LETTER OF INTENT FOR: SADDLEHORN RANCH

824 ACRE CURTIS ROAD SUBDIVISION

Final Plat Filing No. 2

Saddlehorn Ranch Filing No. 2

A PARCEL OF LAND LOCATED IN THE SOUTH HALF OF SECTION 3 AND THE NORTH HALF OF THE NORTH HALF OF SECTION 10, TOWNSHIP 13 SOUTH, RANGE 64 WEST OF THE 6TH PRINCIPAL MERIDIAN, EL PASO COUNTY, STATE OF COLORADO

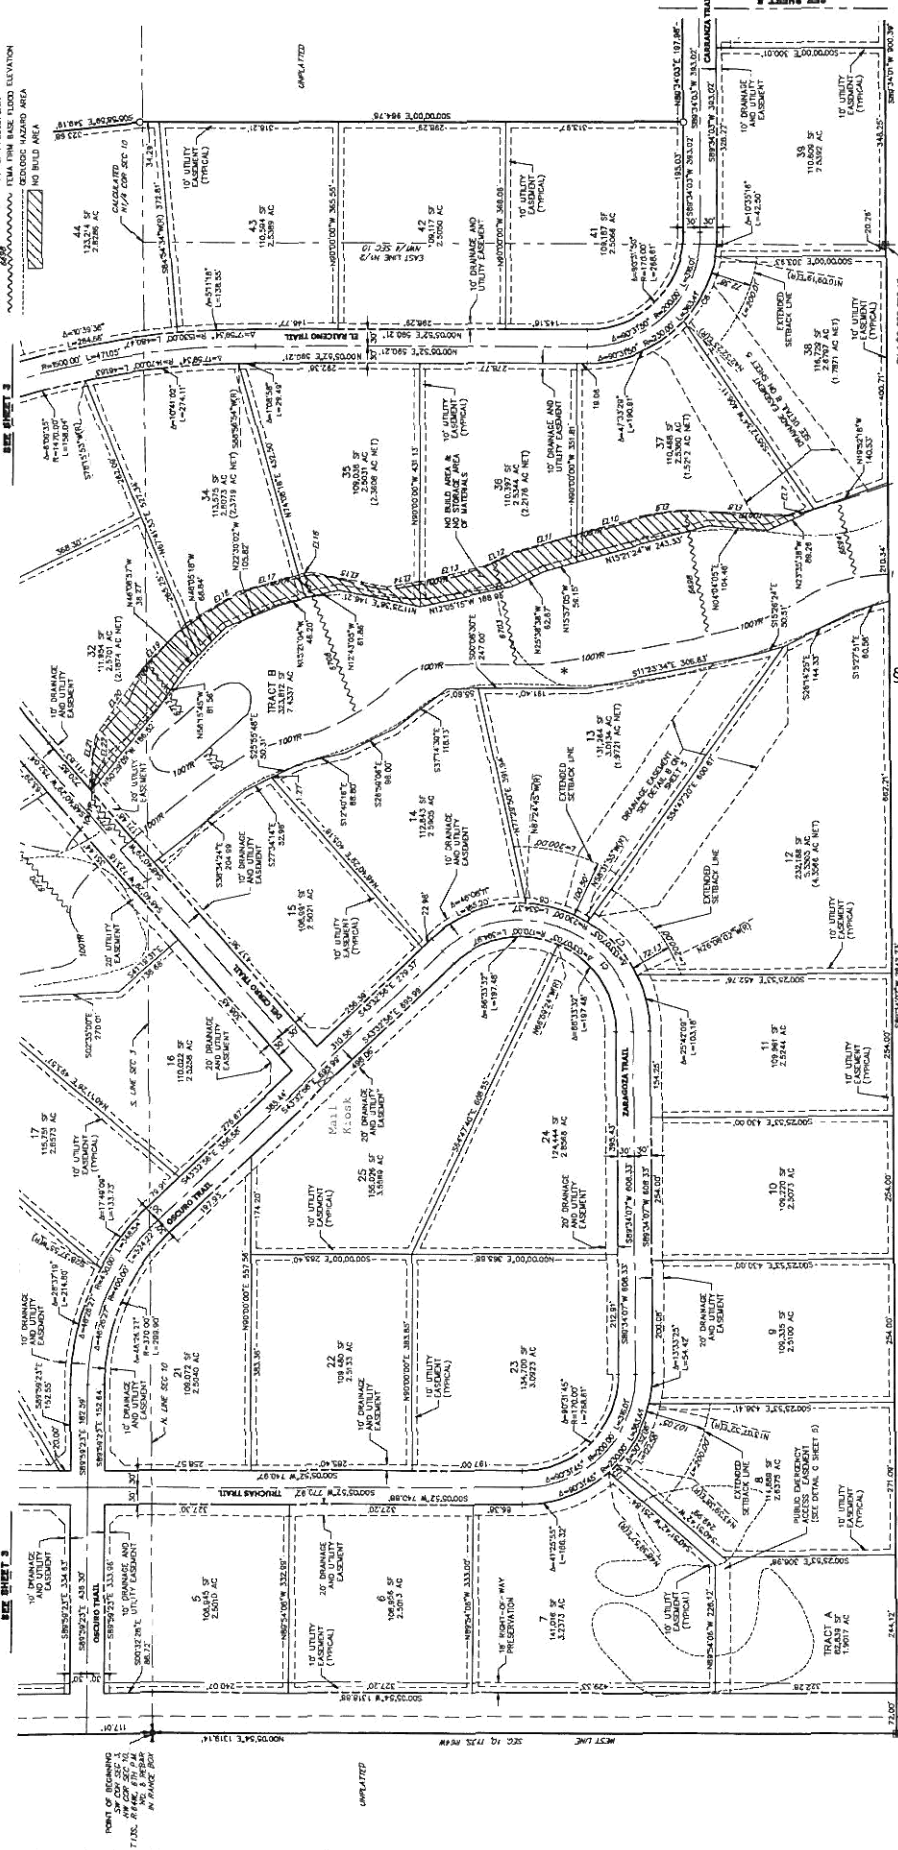
This is in conflict with the data provided on the plat. Please revise acreage throughout, as it is incorrect.

Filing 2? Overall is 816 acres?
